Brad Horsley Construction
 Shawna Residence
 4065 Crosslen Lane
 Colorado Springs, CO. 80908

PAGE INFORMATION
 FOUNDATION
 LOWER LEVEL FLOOR PLAN

Sheet Number
AI

PLOT PLAN  
 SCALE 3/32" = 1'-0"

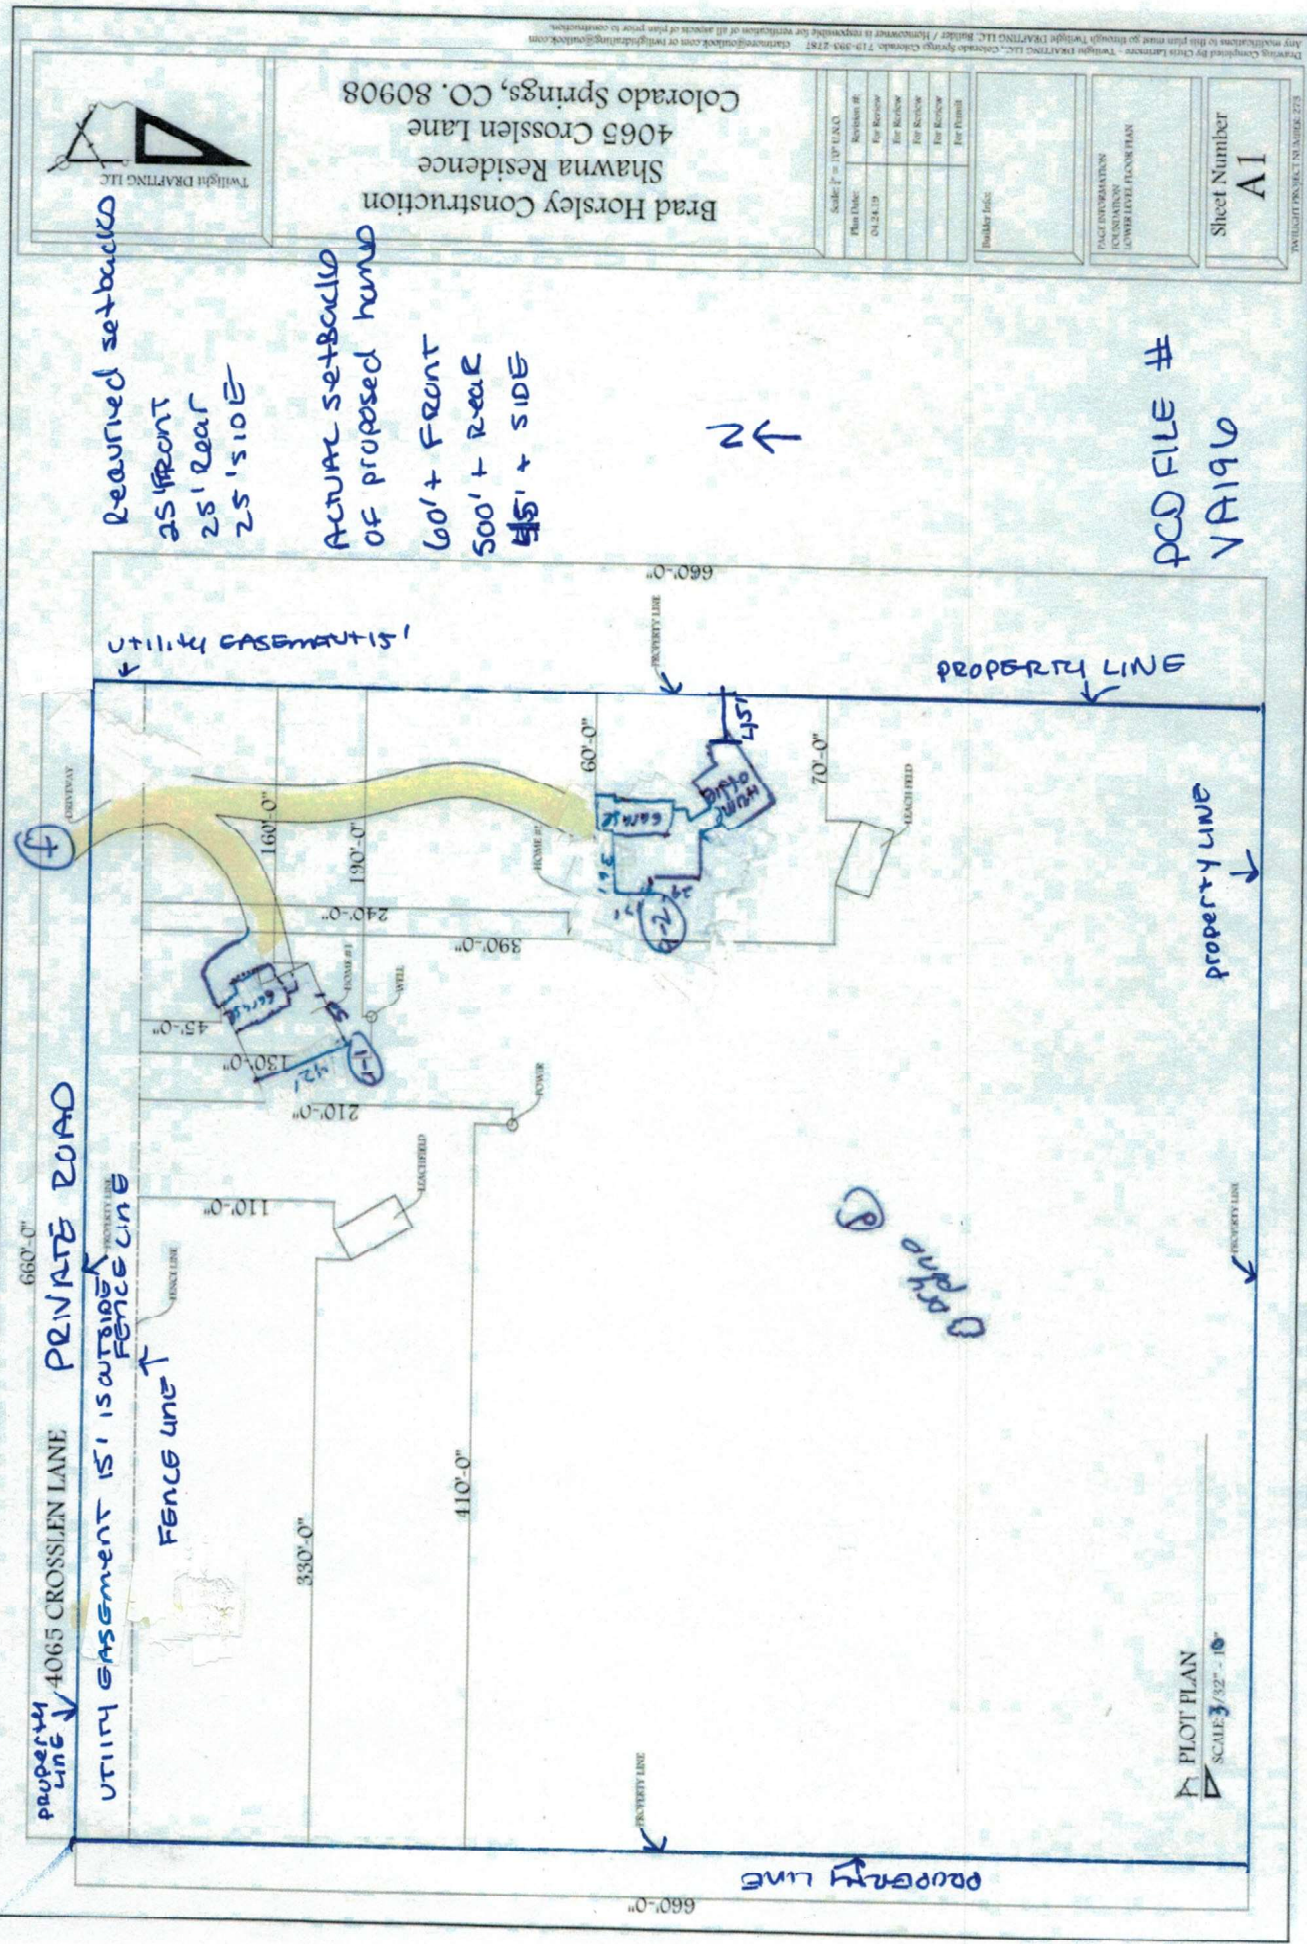
Please identify the adjacent property owners to the east, west, and south (provide the owner and address or parcel #)

Please add PCID
 File No. VA196

Please label the road as "(Private)"

Please indicate if this access is going to remain or be removed.
